ENG-SF20028-R2-FDR.pdf Markup Summary

URBAN COLLECTION AT PALMER VILLAGE	SWALE CROSS SECTIONS	GEC PLANS
SHEET 3 OF 10	JOB NO. 25149.01

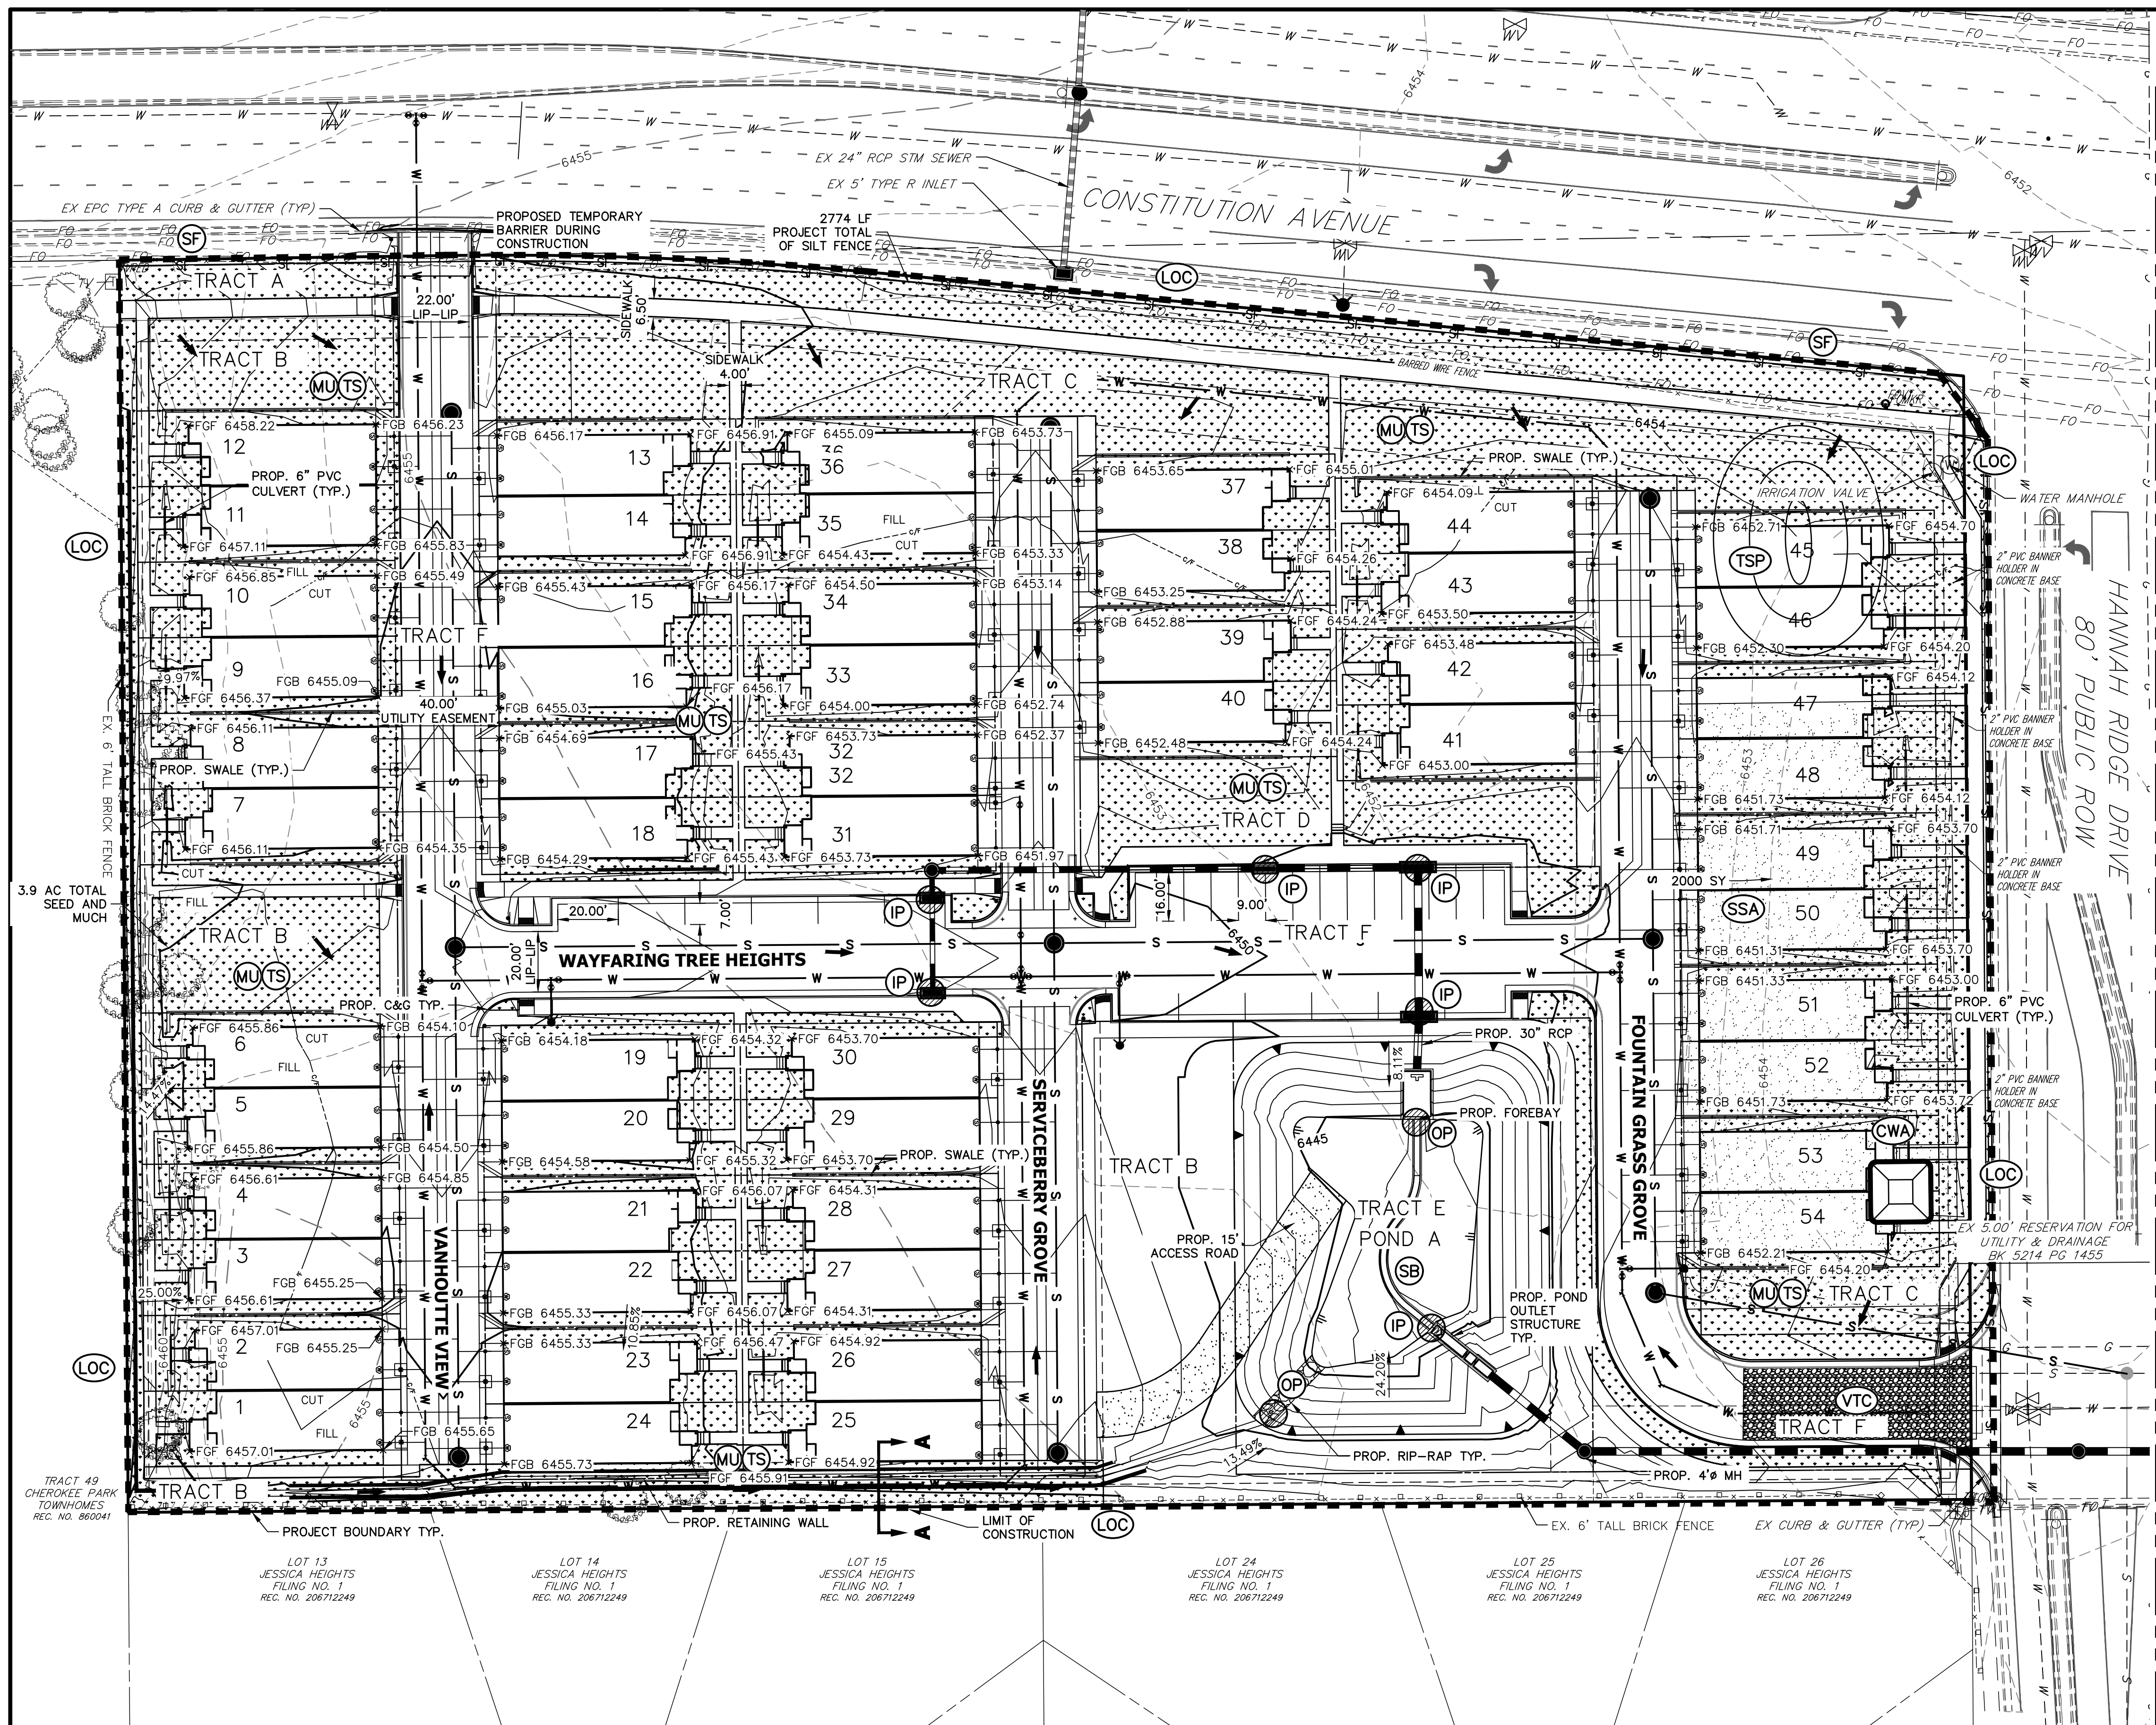
verify that the swale is deep enough and there is no offsite grading
